Subject: FW: CM/48/201/DOC - Bairds Farm Shop, Field Rear of Crookthorn Lane, Climping, BN17 5SN

| DWG NO<br>003                                           | REVISION<br>P5 |                  |                                                        |                                                   |

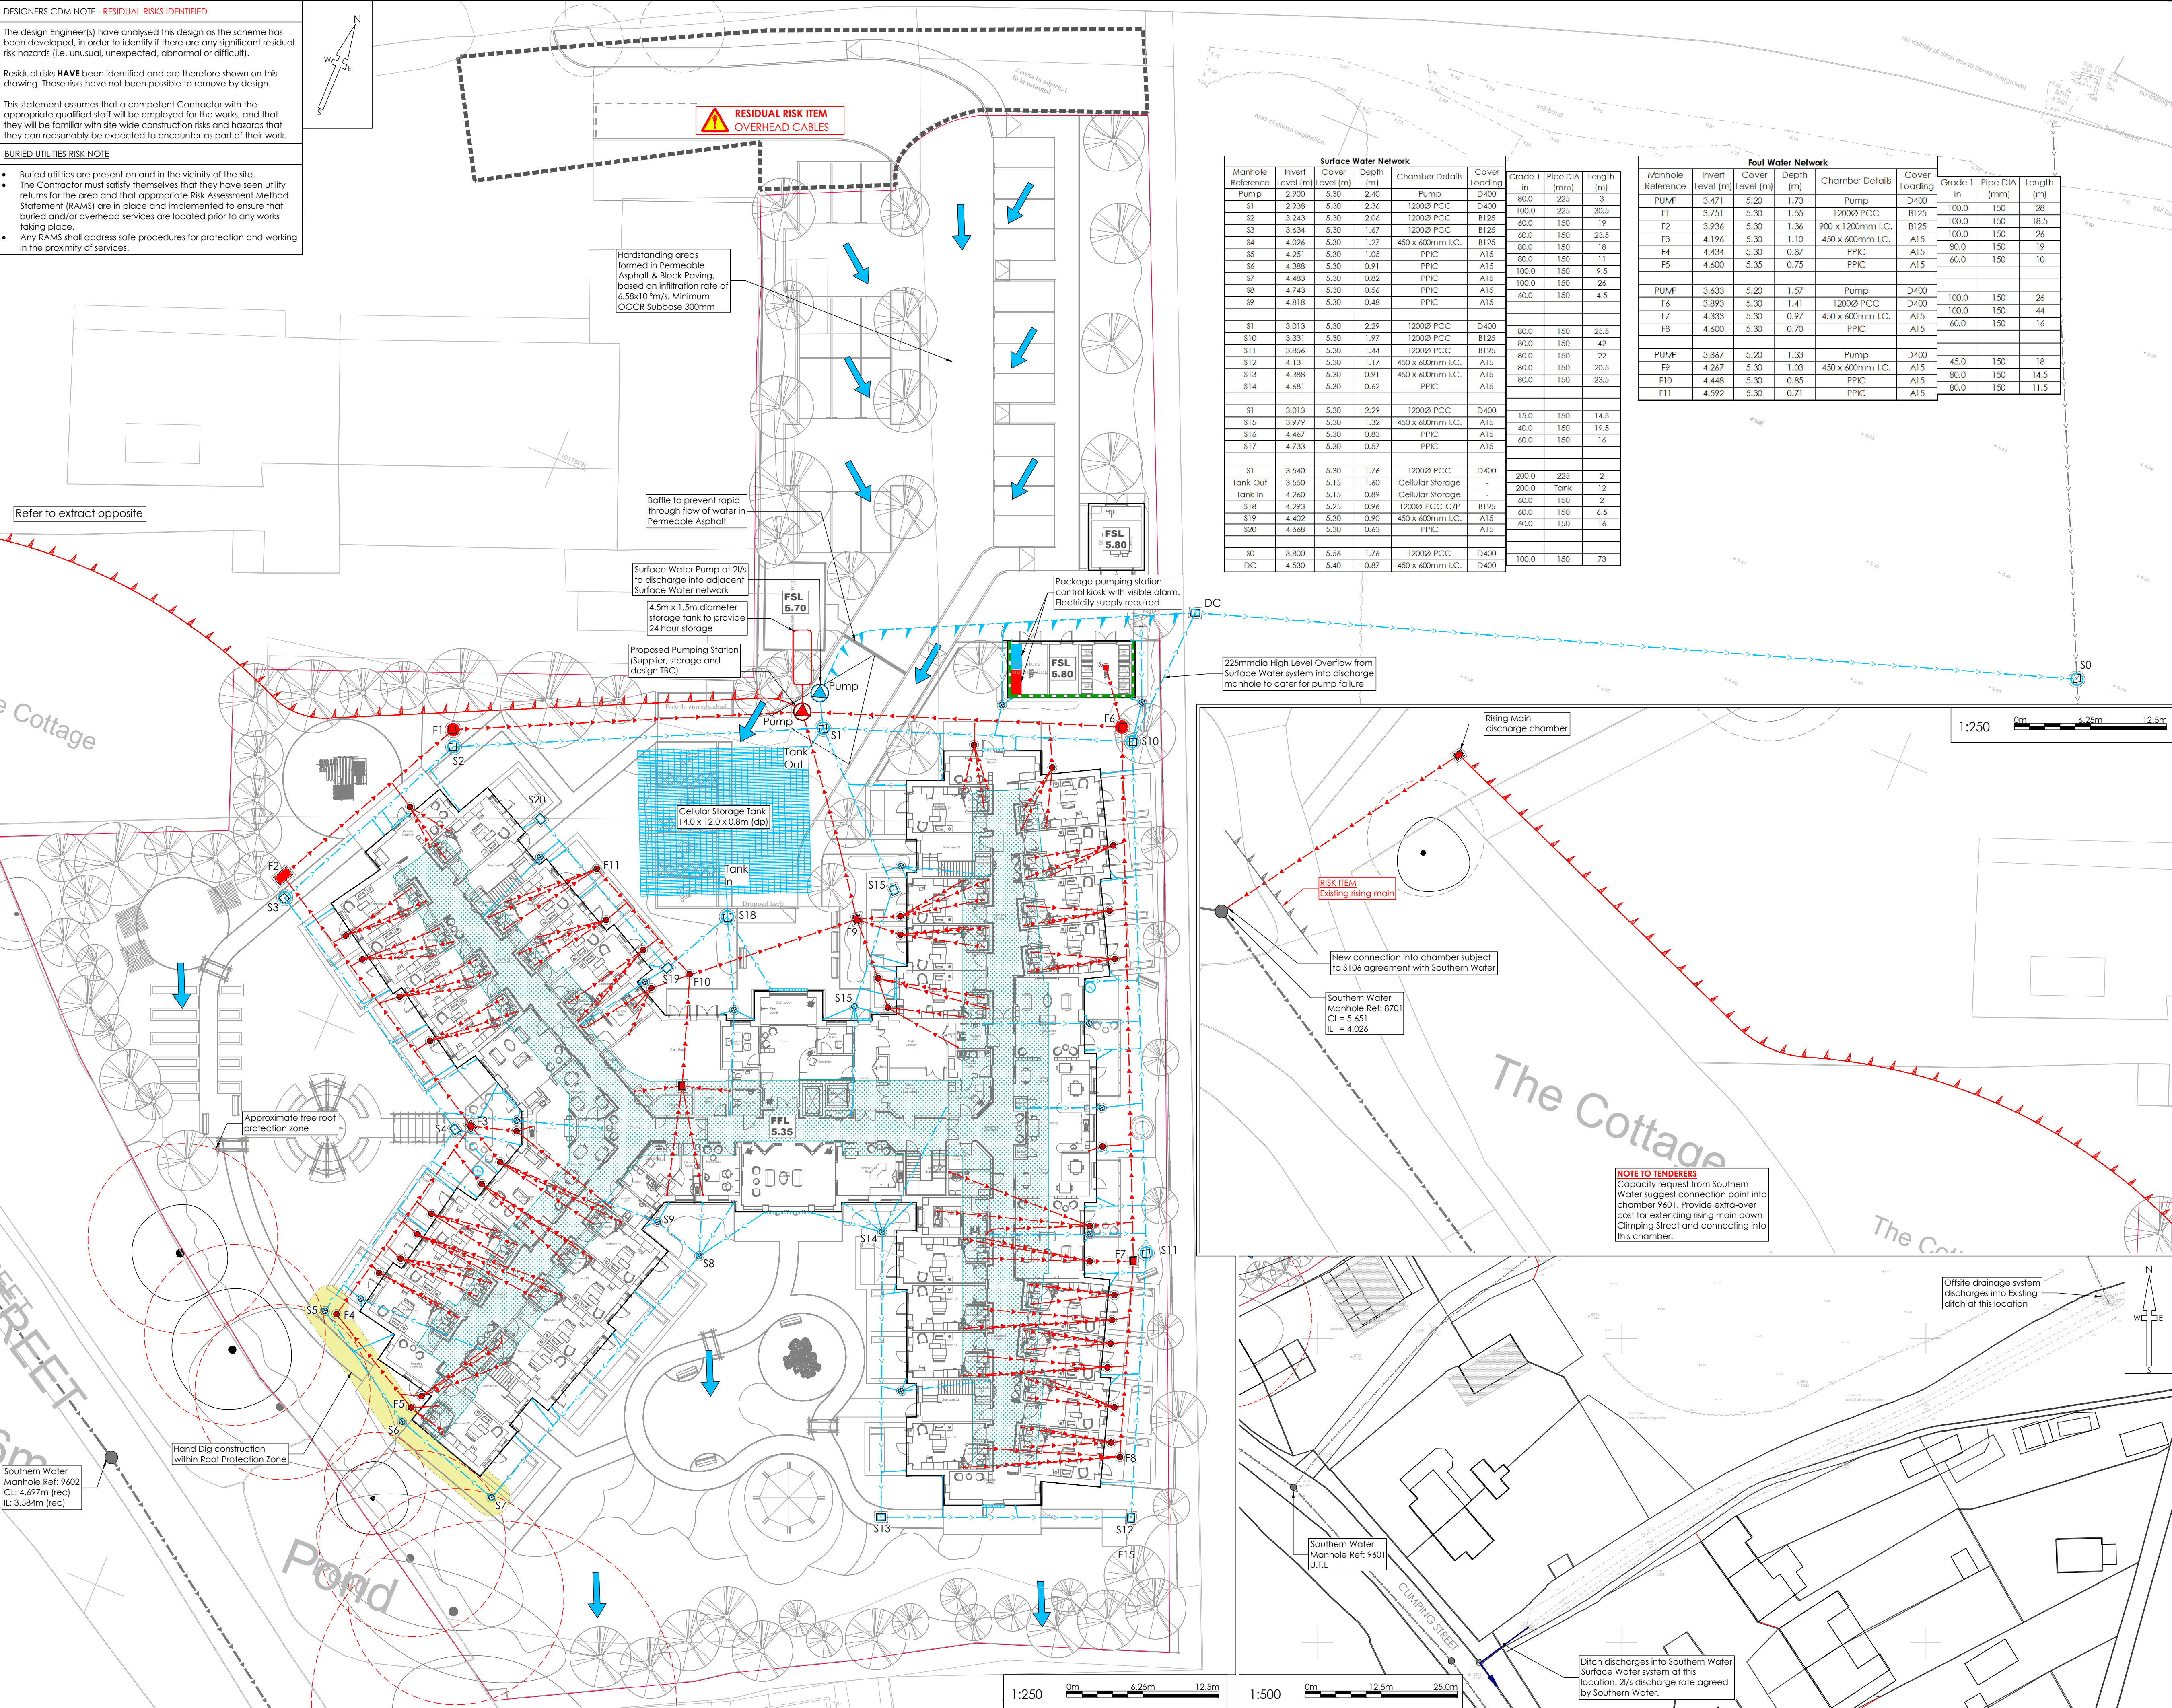
You haven't included a cap volume depth within your calculations. The 0.3 porosity does not extend to the height that is in the calculations, water is above the sub-base. Please apply an appropriate cap volume depth.

1. Please supply a figure showing the groundwater monitoring locations.
2. I note that Soakaway E has an invert at over 1m depth, based on the groundwater monitoring results near this location the design may need to be revised. (potentially link provided between permeable paving and this soakaway to ensure you have the required volume above peak groundwater level?)
3. Please supply a catchment plan- i.e. a layout which clearly shows the areas (and the size of these areas) that are draining to each soakaway.
4. Please label all pipes with diameters and falls.
5. We will require updated construction detail drawings and maintenance manual. Please include on the construction detail drawings the required crate type- or criteria they have to fulfil in terms of minimum acceptable cover depth.

Thanks for the email. Our intention is/was to extend the sub base of the permeable paving above soakaway E down to the top of the crate storage to interlink them hydraulically. We've expanded the note on the drawing to make this clearer.

1. We have added on the groundwater test locations and referred the depths back to existing ground levels to provide the levels of the groundwater. *Okay, point closed.*

2. Soakaway E does have a low invert however this is purely a result of having to provide additional cover over the crates to ensure that they will be able to take vehicle loadings. Lifting the crates higher will compromise their strength however we intend to link the permeable sub base with the soakaway to provide additional hydraulic storage to address this. We attach the calculations for the soakaway and soakaway plus permeable paving. *The peak groundwater level in this area is above the top of crates. It doesn't appear that you have sufficient volume in the permeable paving sub-base alone. I have calculated you have 22.68m³ volume available in the permeable paving sub-base, calculations indicate you require 55.6m³ of volume. Adequate storage must be provided above peak seasonal groundwater level, please demonstrate you can provide this. Please confirm how you intend to link the crate and permeable paving, is it via increasing the sub-base depth, if so then you may be providing the storage required.*

PERMEABLE ACCESS ROAD DETAIL

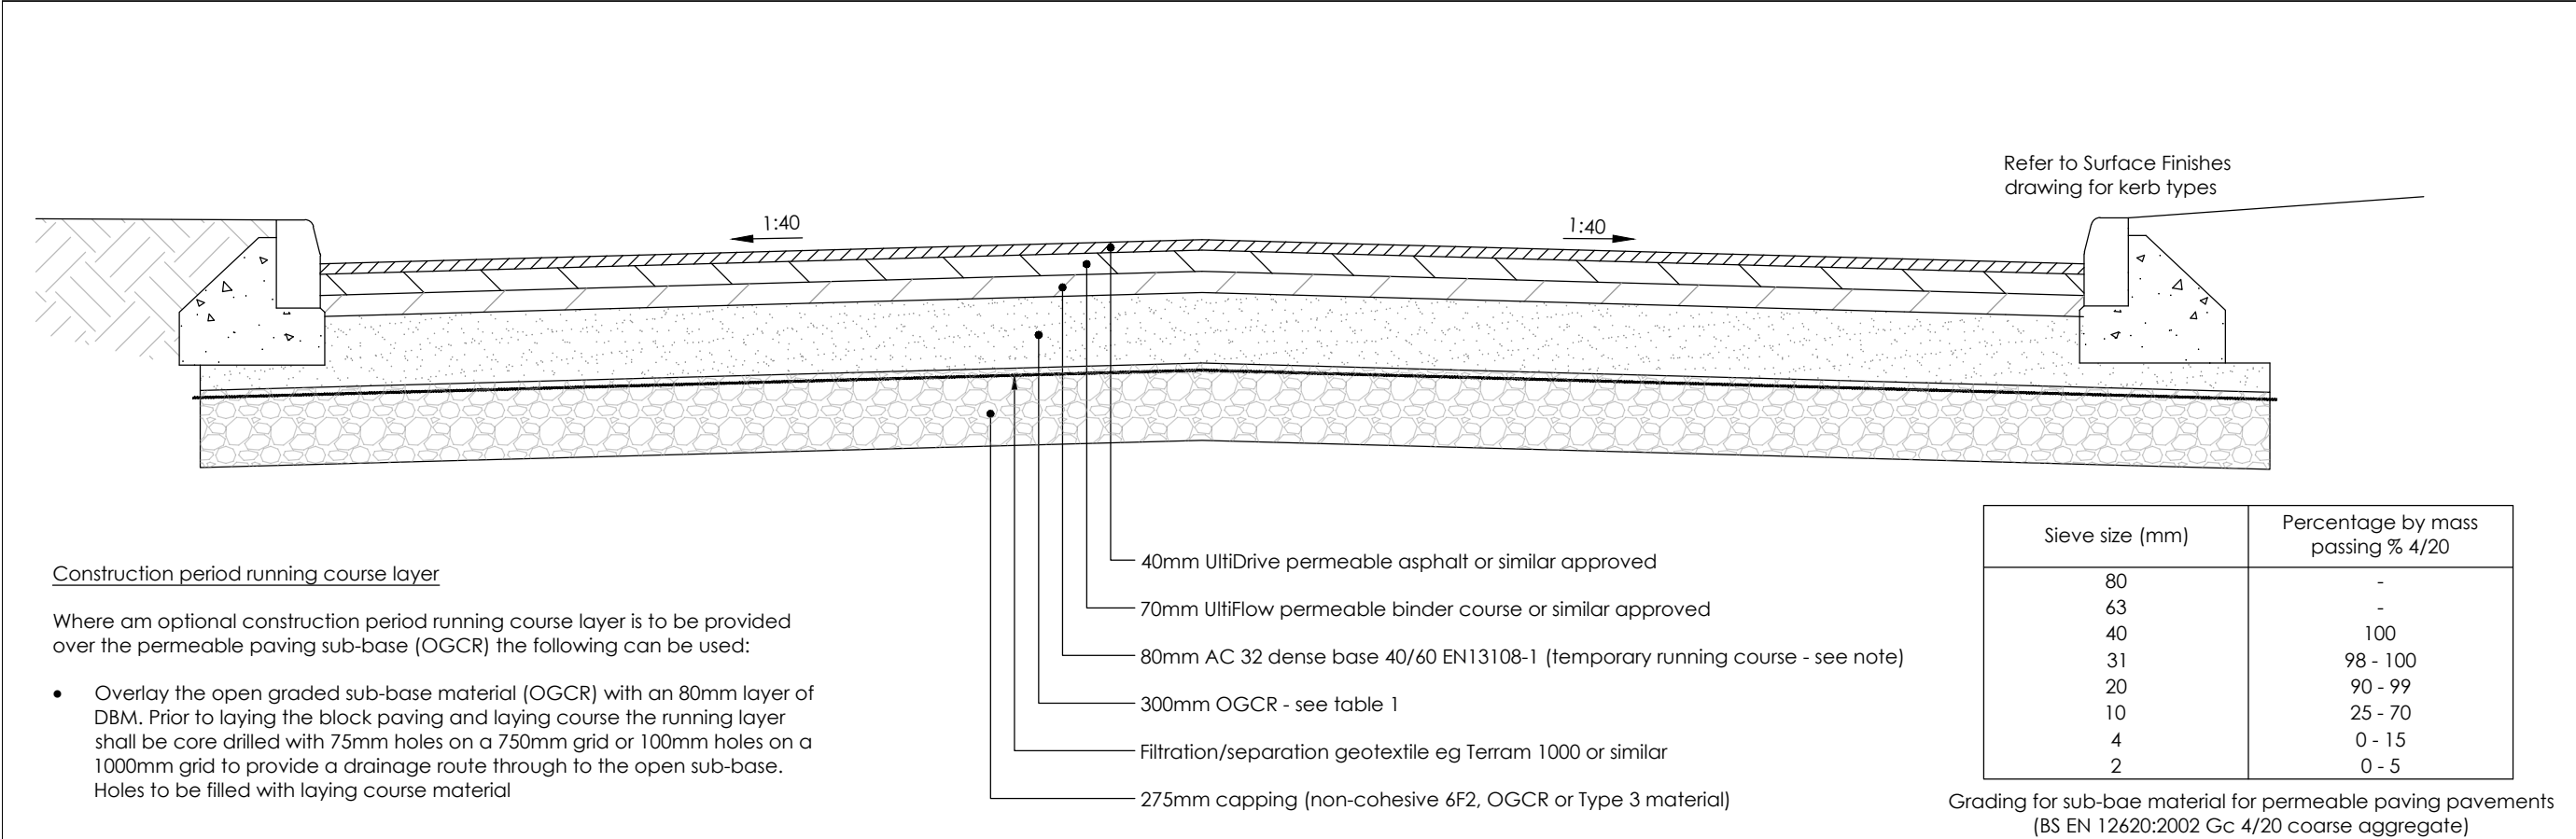
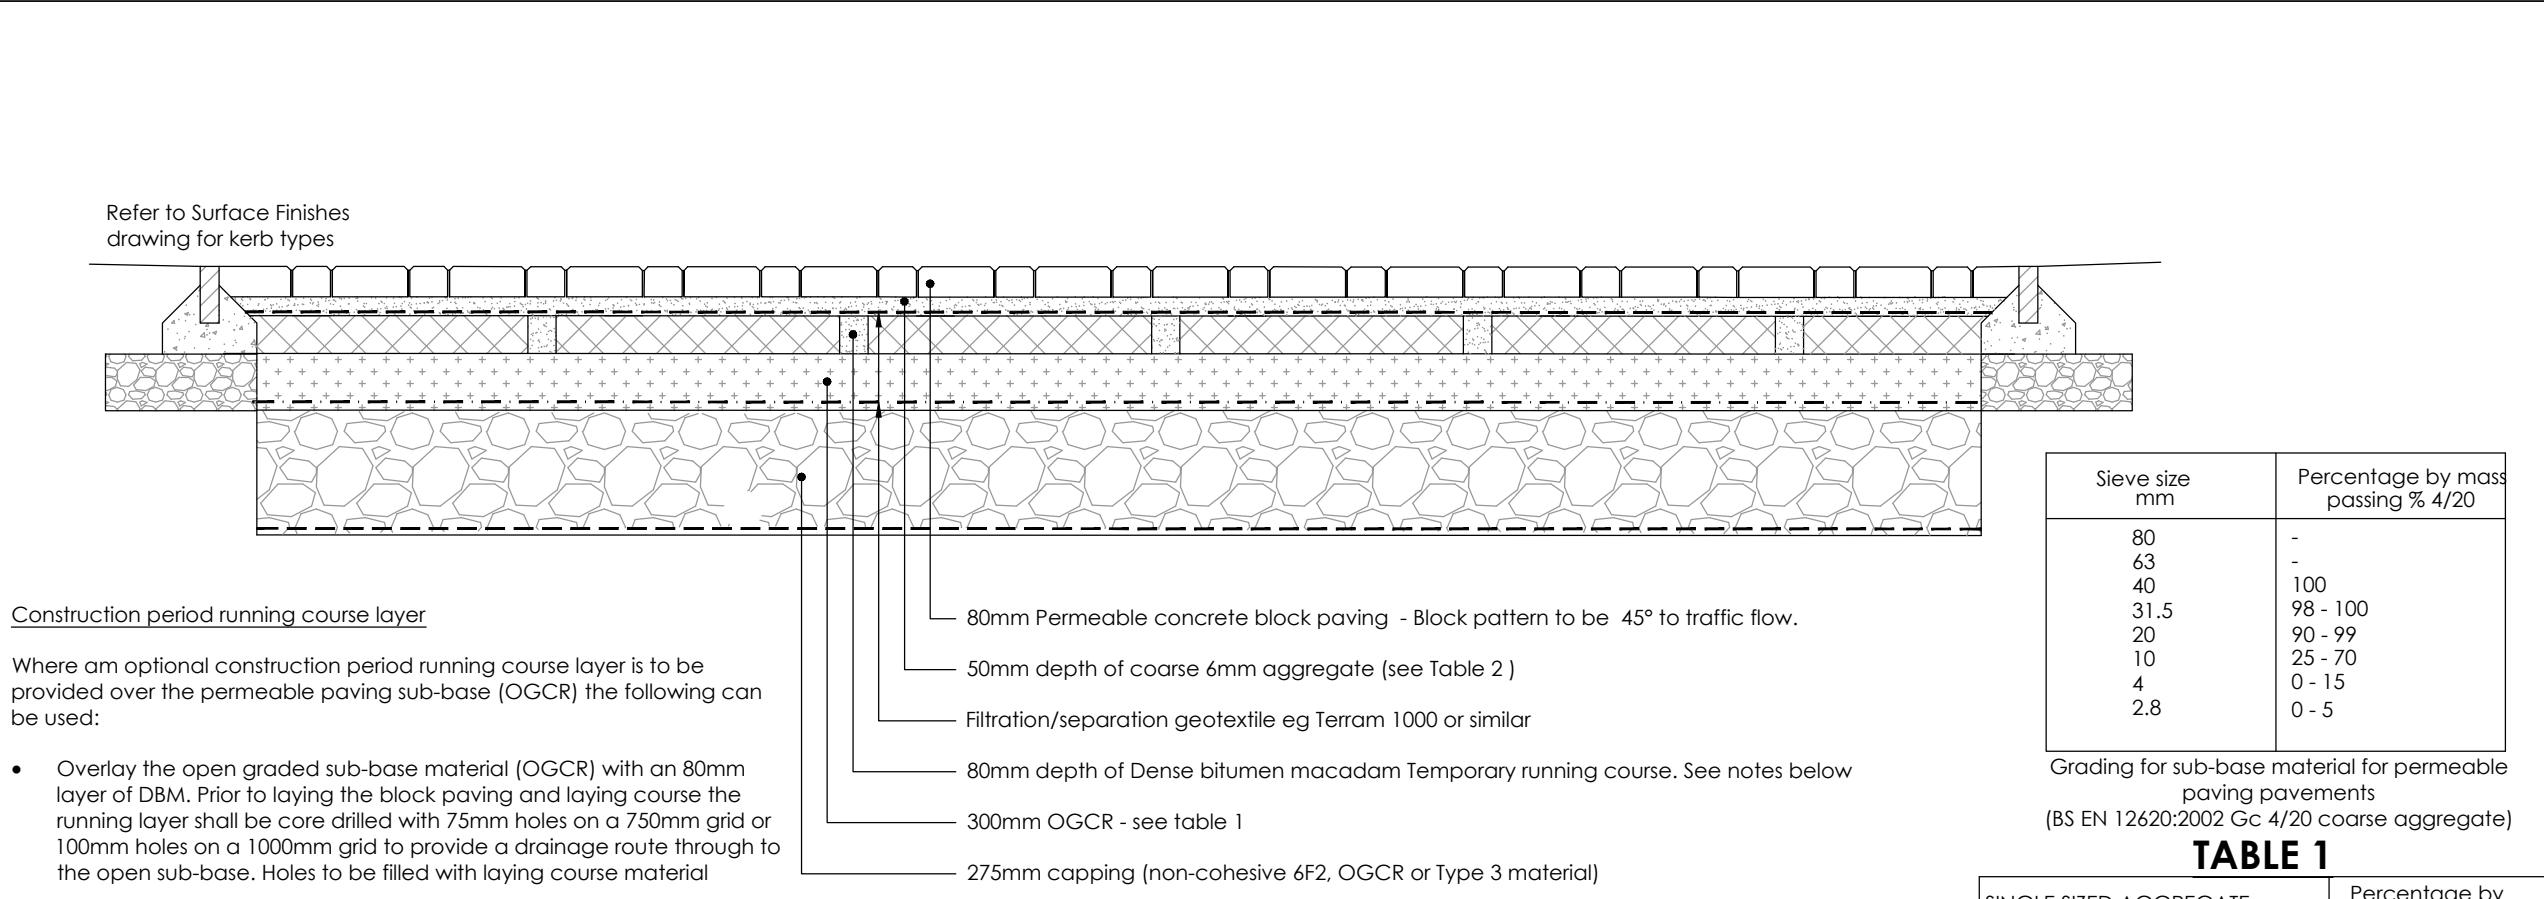
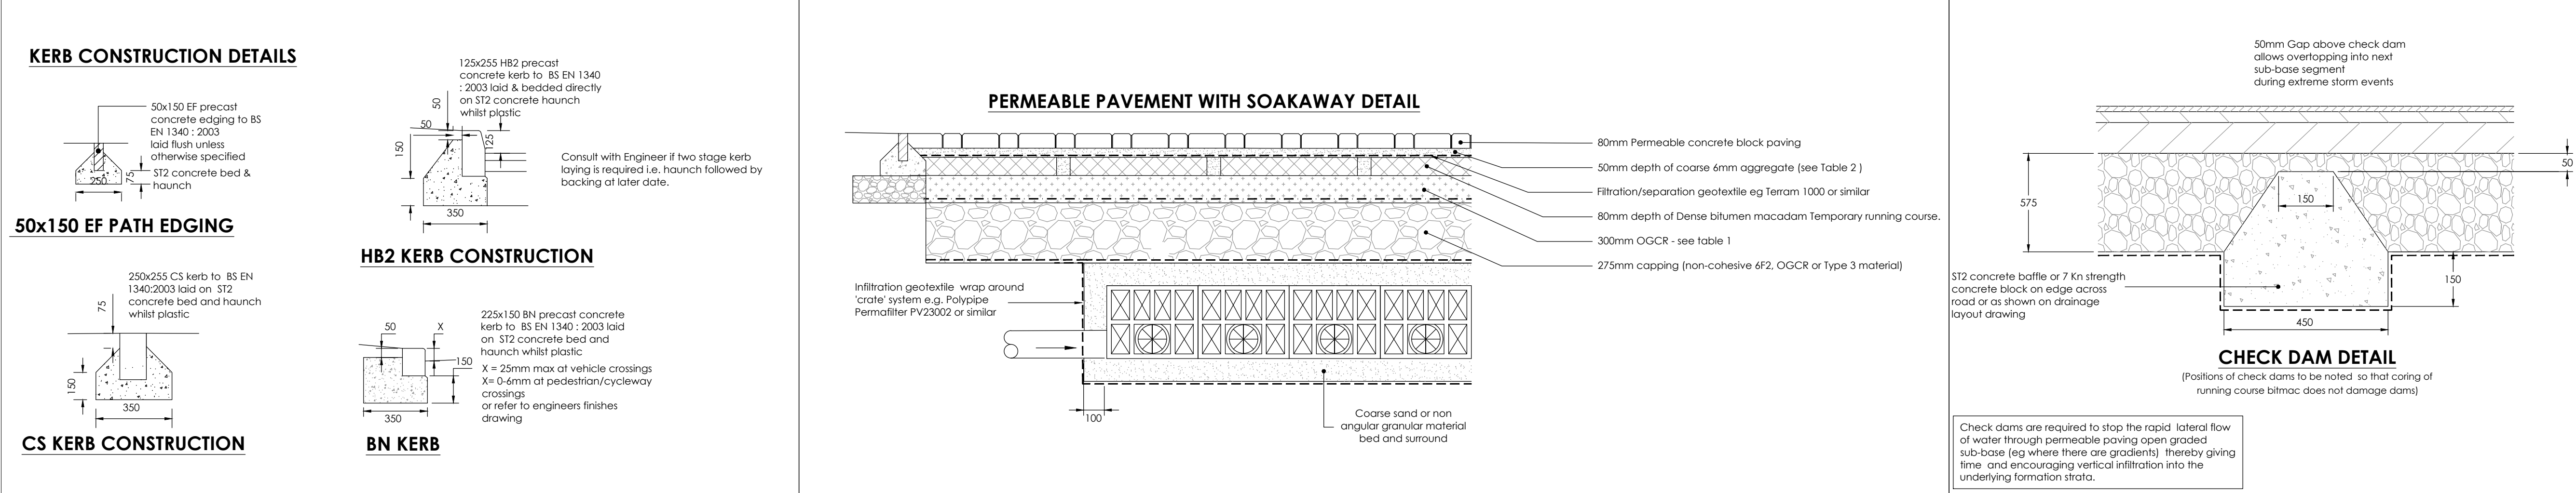
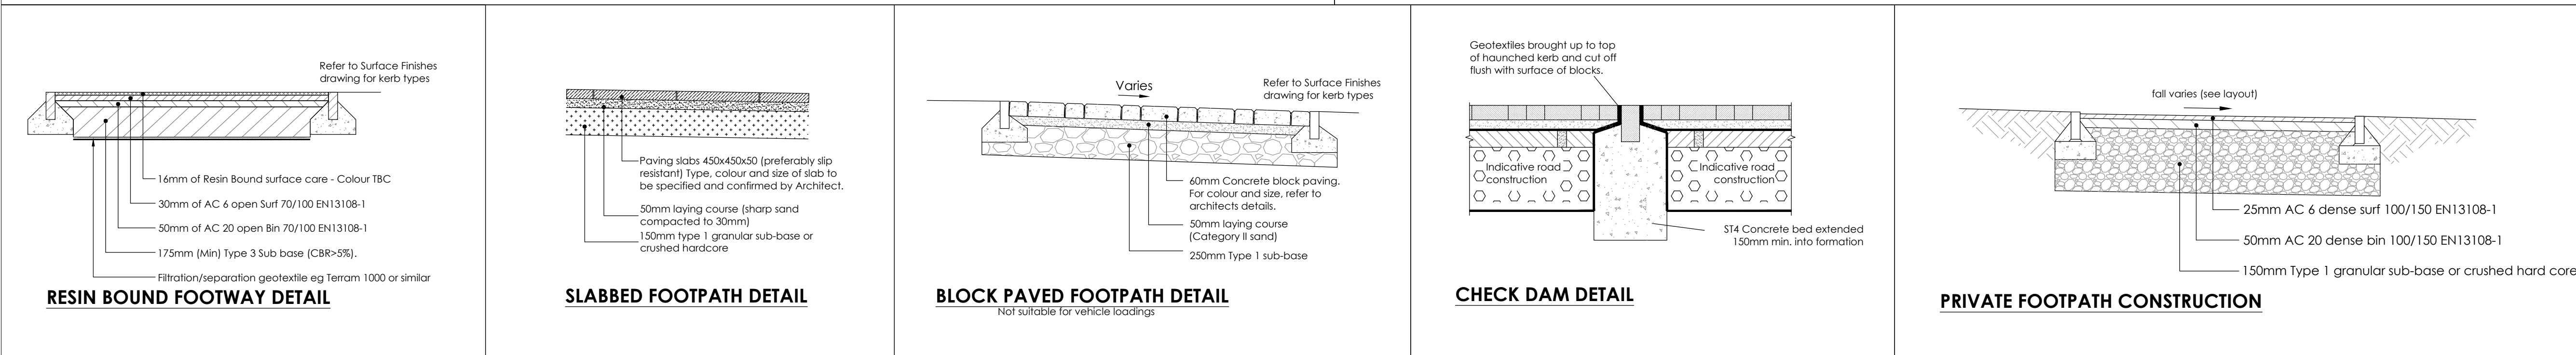
Please provide a construction detail drawing which clearly shows the linkage of the permeable paving sub-base with the crates here. I note you have also now introduced a baffle into the sub-base here, please provide a construction detail drawing of this.
